From: Alistair Flatman [REDACTED]
Sent: 19 January 2018 15:00
To: Anita Gardner
Subject: Re: Proposed KFC at Fontwell - LPA ref WA/88/17

Dear Alistair,

For clarity I have reproduced the environmental health officer's comments below with my comments beneath.

PROPOSED GENERAL
ARRANGEMENT PLAN

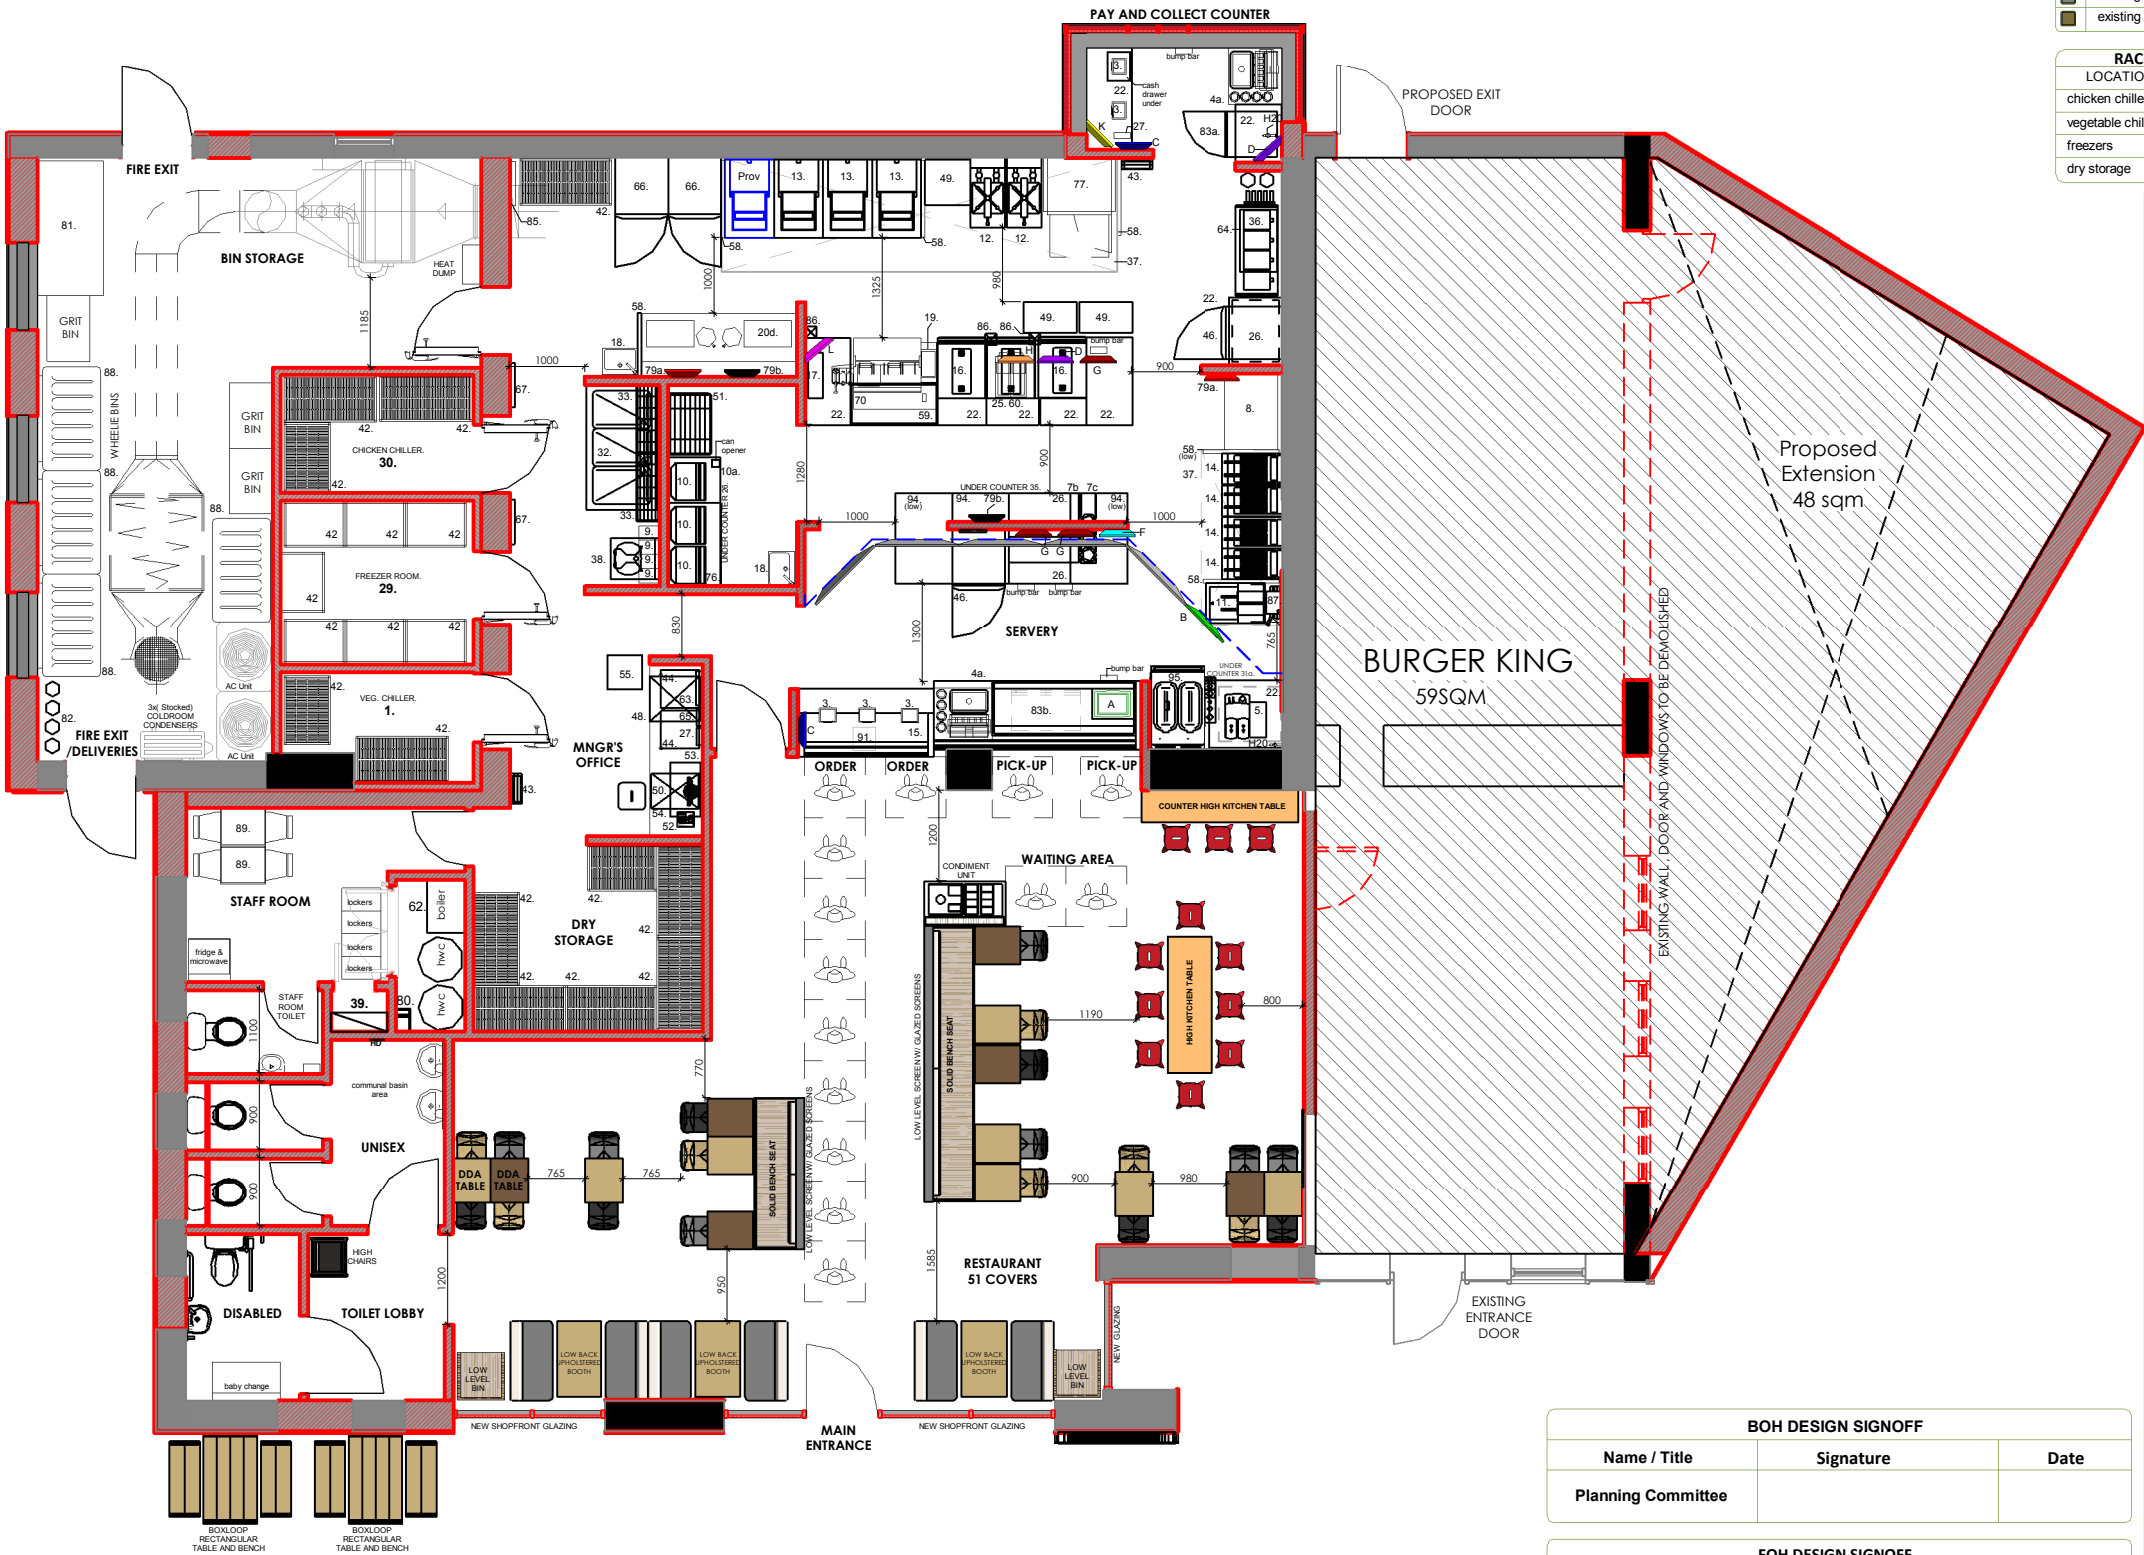
1. The application letter states "there are no proposed works to the attached Burger King unit" but the plans show a 48 sq m triangular extension. Which is correct? Is Burger King being extended or not?

This should be clarified

4. Can the applicant confirm whether they consider the number of wash-hand-basins in the KFC kitchen to be sufficient (2 no.).

1. There are no external alterations or extensions proposed to Burger King. There may be an internal refit but no external changes are proposed
2. We would be happy to accept a condition restricting the hours of operation of the KFC and drive thru to 0700-2300. Would that be acceptable - my thoughts are that this would address EHO concerns on movements / noise and also comments raised by residents.
3. With regards the boundary with Travel Lodge - could boundary details / landscaping be conditioned?
